PLANNING CONSULTATION RESPONSE

Application No	2025/0532
Proposal	Conversion of vacant church and church hall; installation of first floor in church building and associated works to create 11 residential apartments (Use Class C3).
Address	Wesleyan Reform Church, Wakefield Road, Smithies, Barnsley, S71 1NP
Date of Consultation Reply	17/07/2025
Consultee	Charlie Atkinson Design and Conservation Apprentice

Updated comments as of 24.03.2026 -

Project	Proposed Change of Use of Existing Church to 11 No Apartments at 175 Wakefield Road, Smithies, Barnsley S71 1NP for Mr G Singh	Date 08/05/2025
Drawing	Proposed Elevations & Roof plan for Building B	A1
		2562
		R
		Scale
		1:100
	Drg No	2

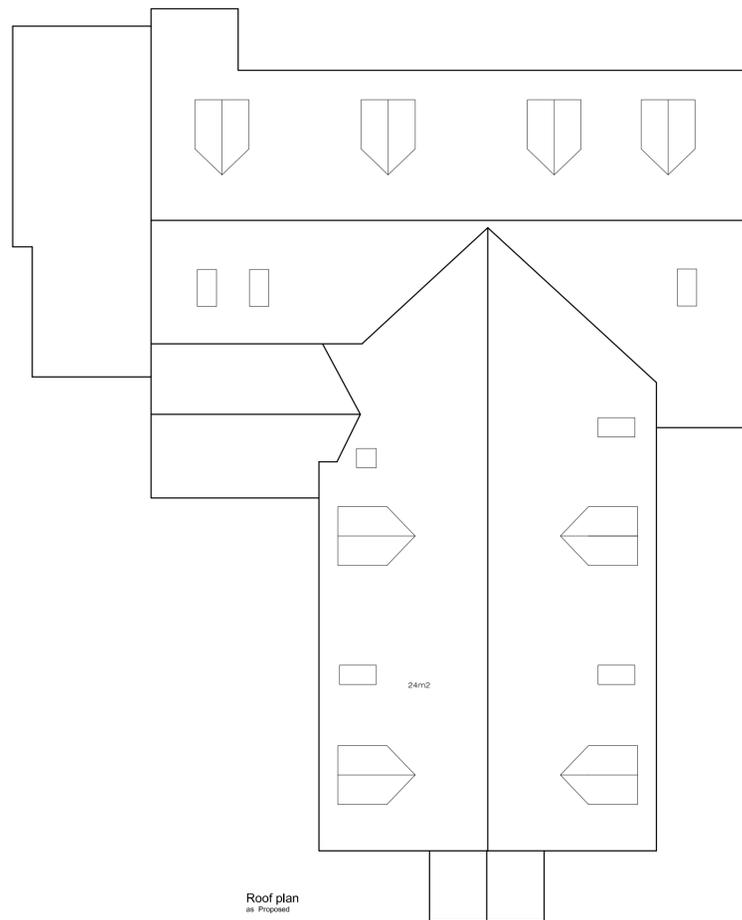
- The removal of the four dormer windows visible from Wakefield Road
- The proposed cladding material for the rear dormers
- The profile and detailing of replacement windows
- The approach to secondary glazing, particularly in relation to stained-glass windows
- The design and treatment of external doors
- The retention and position of interior roof beams
- The installation of the first floor.

We have discussed with the architect and agreed the following. As a compromise in an update about the dormers, a more appropriate design has been provided that includes a decorative bargeboard and a slimmer width. As such, we accept the retention of the dormers with the new design. The cladding material has also been clarified as either lead or a grey

single-ply membrane, which is acceptable. Whilst we are currently unaware if all windows and doors will be replaced, we would suggest the following conditions.

Heritage style dormer

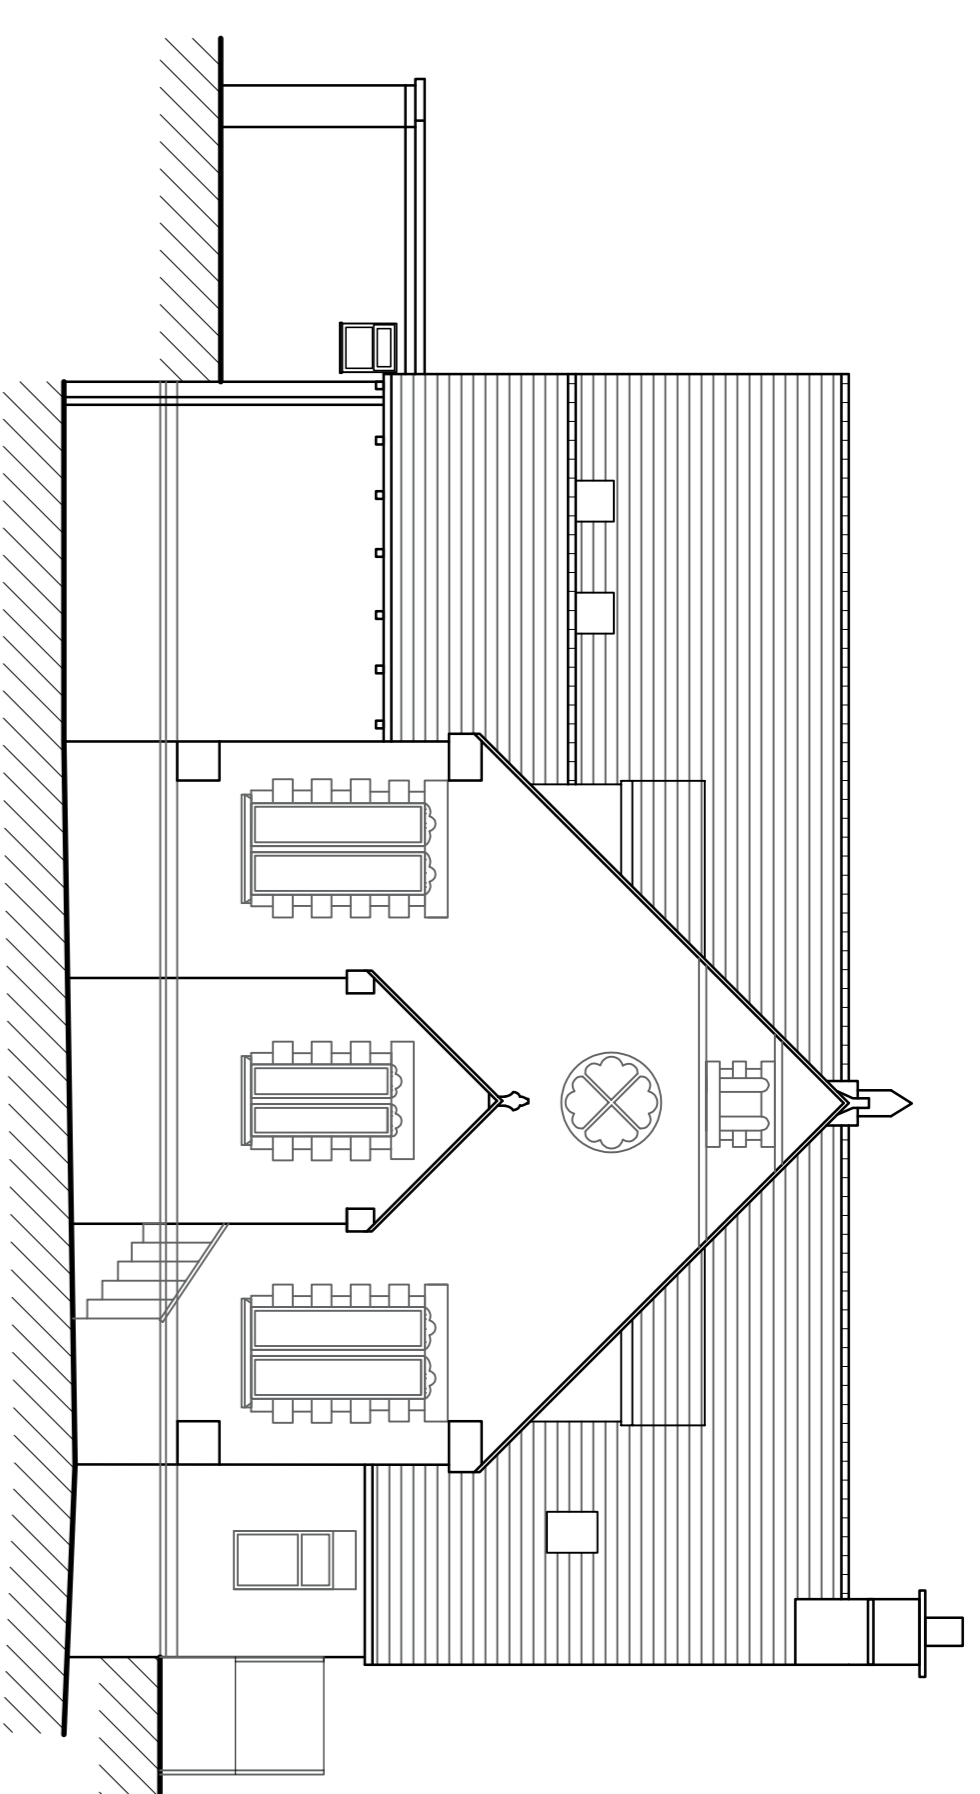
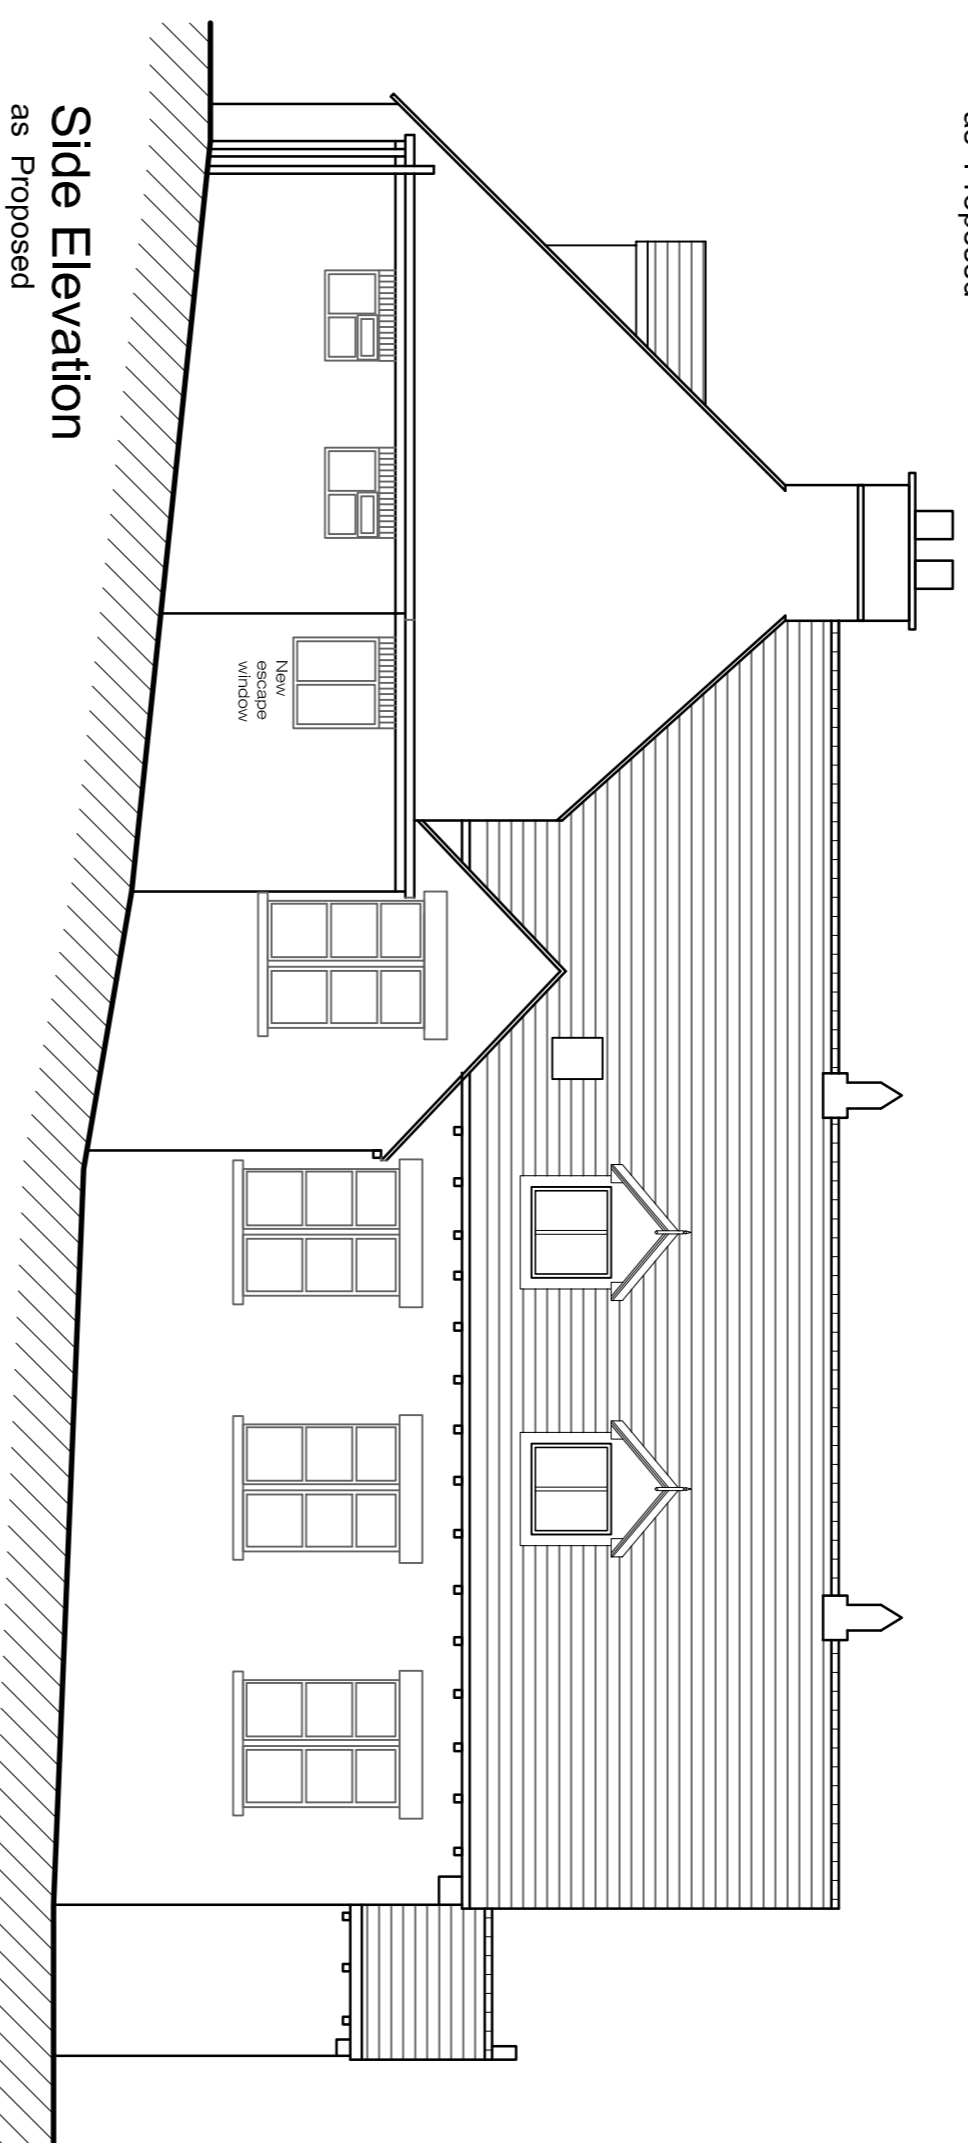
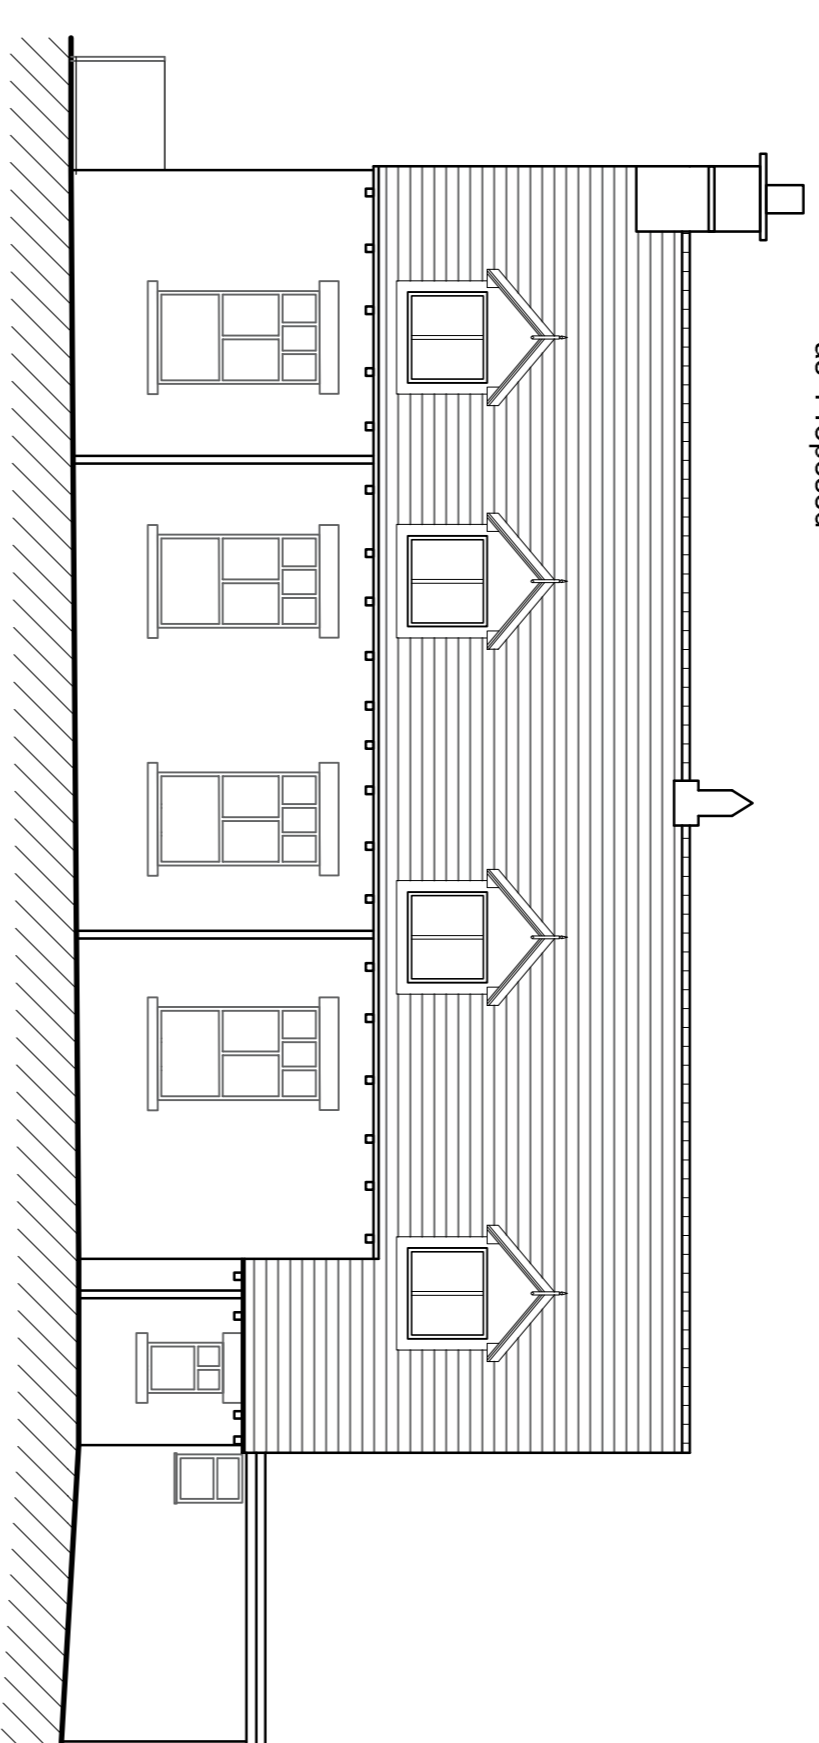
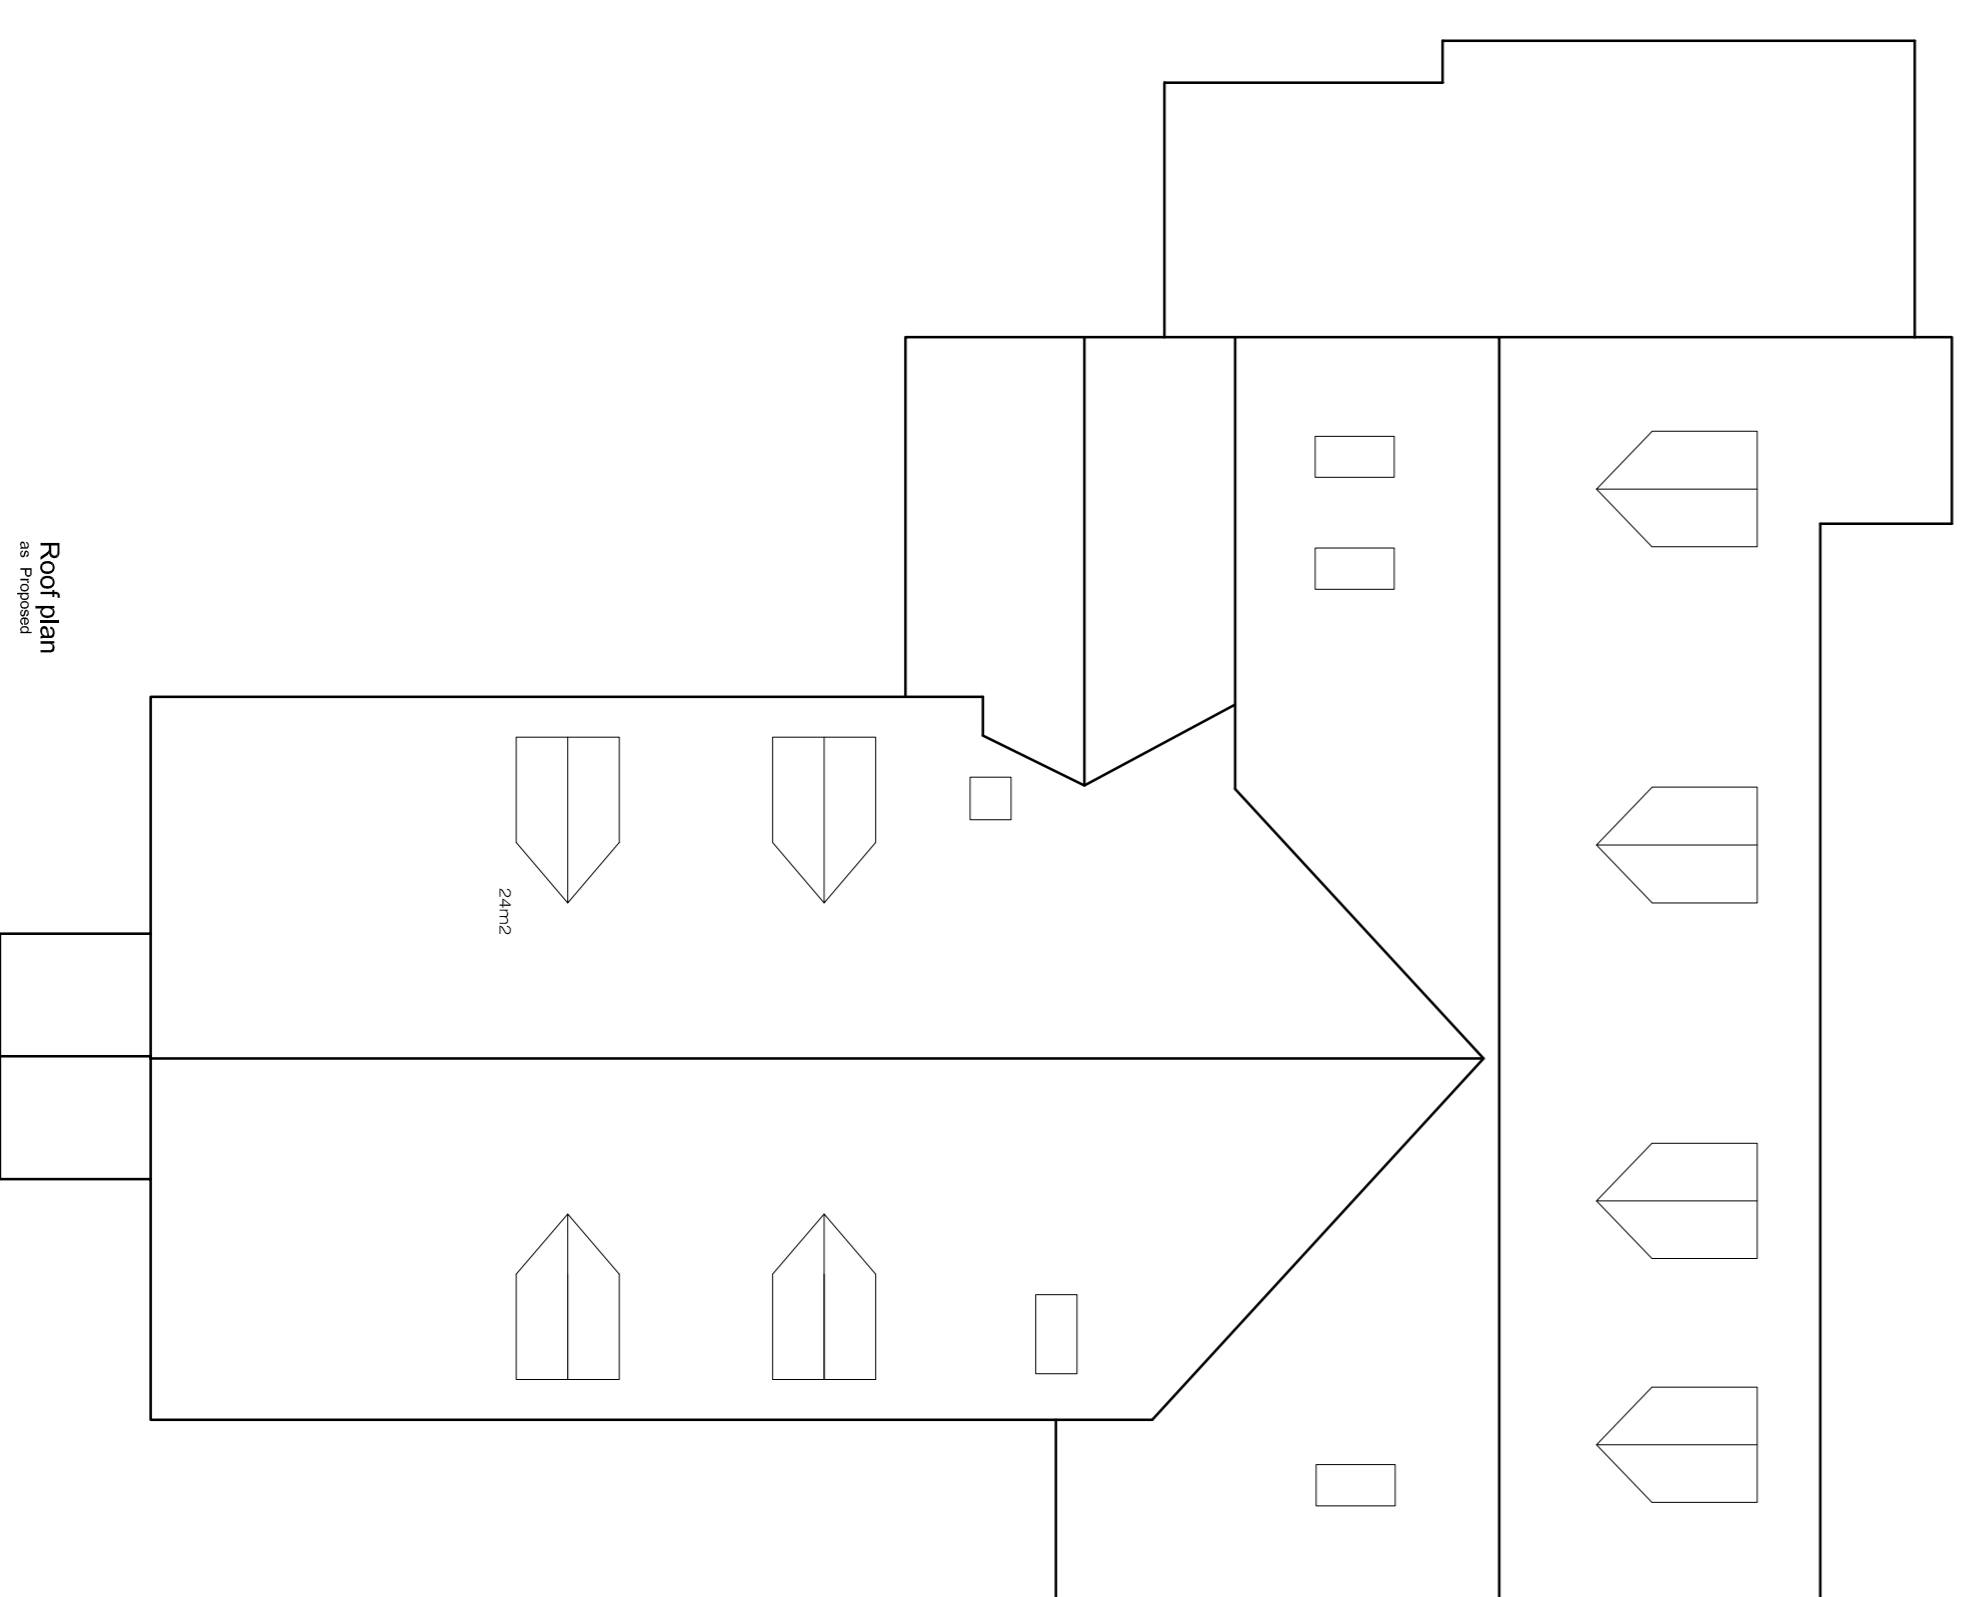
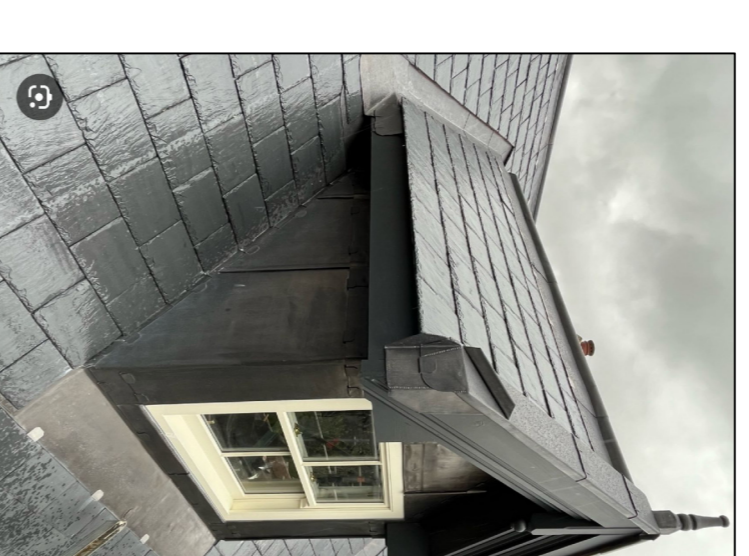
- The removal of the four dormer windows visible from Wakefield Road
- The proposed cladding material for the rear dormers
- The profile and detailing of replacement windows
- The approach to secondary glazing, particularly in relation to stained-glass windows
- The design and treatment of external doors
- The retention and position of interior roof beams
- The installation of the first floor.
